**To: All Staff**  
**From: Environmental Health**  
**Date: 03/23/2026**  
**Subject: BL-26-00002 Fowler Creek Trails**

RECORD OF SURVEY A PORTION OF THE NE 1/4 OF SECTION 3, TOWNSHIP 19 NORTH, RANGE 14 EAST, W.M., KITITAS COUNTY, WASHINGTON

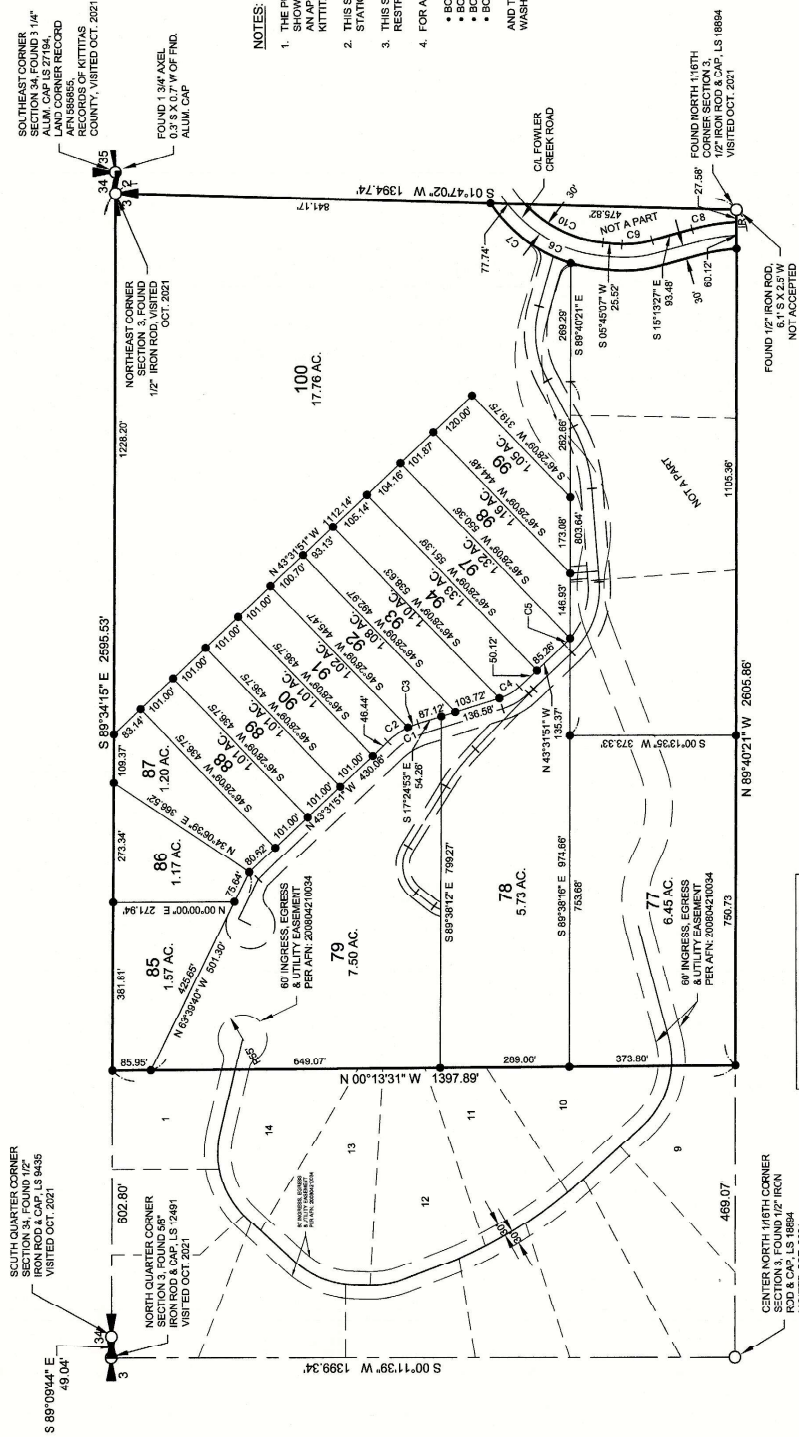
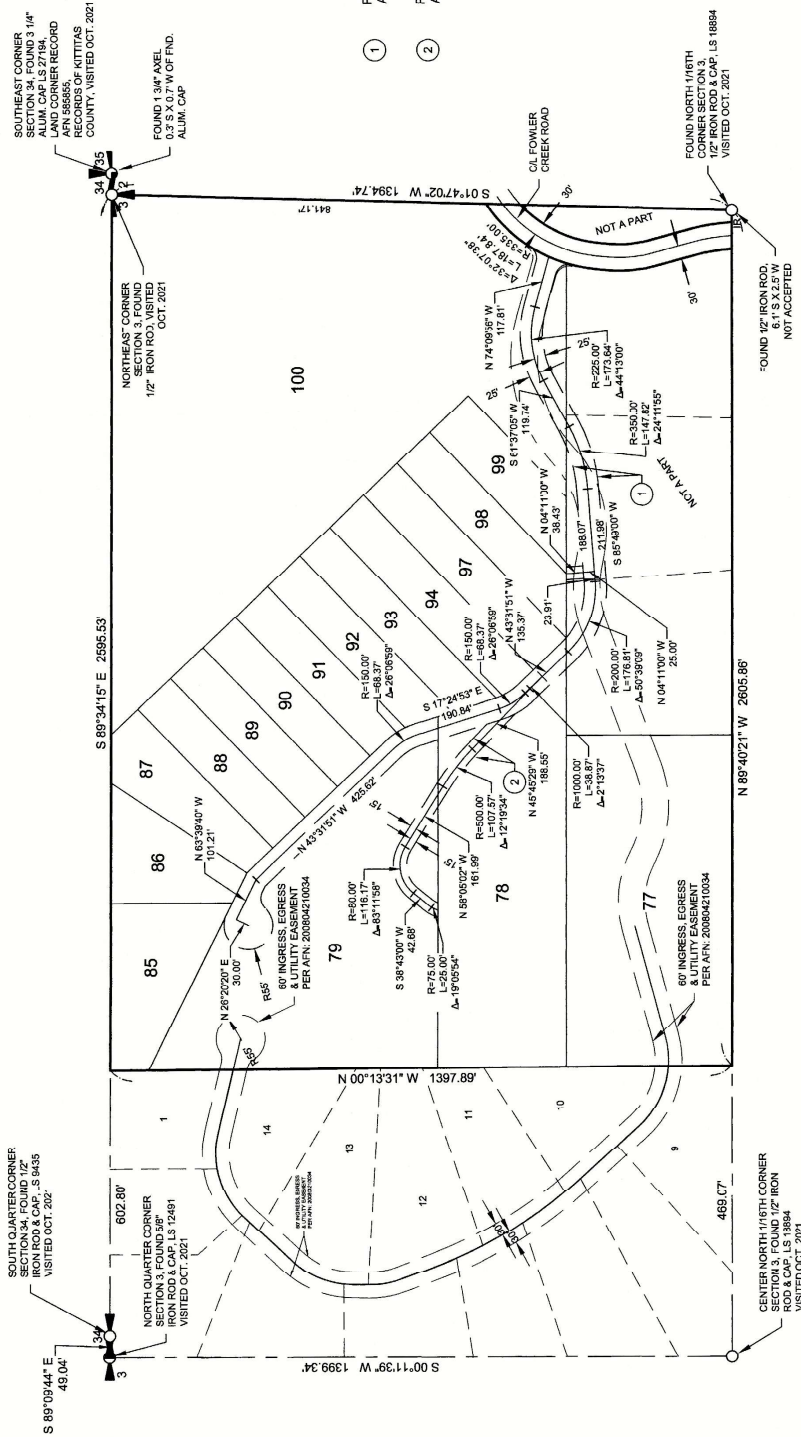
<b>Drinking Water</b>	<ul style="list-style-type: none"><li>I spoke with Pat Deneen about the 2 wells on the Fowler Creek Trail map to get clarification. The well in between lots 87 and 88 serves the Granite Creek Water system and the well on lot 85 and 90 serves the house on lot 77. Therefore, this well must meet the set back of 50' from property lines as per 13.20.040 county code.</li></ul>
<b>Wastewater</b>	<ul style="list-style-type: none"><li>No permits were located for the septic system serving the house or associated parcels. All septic systems must meet required setbacks.</li></ul>
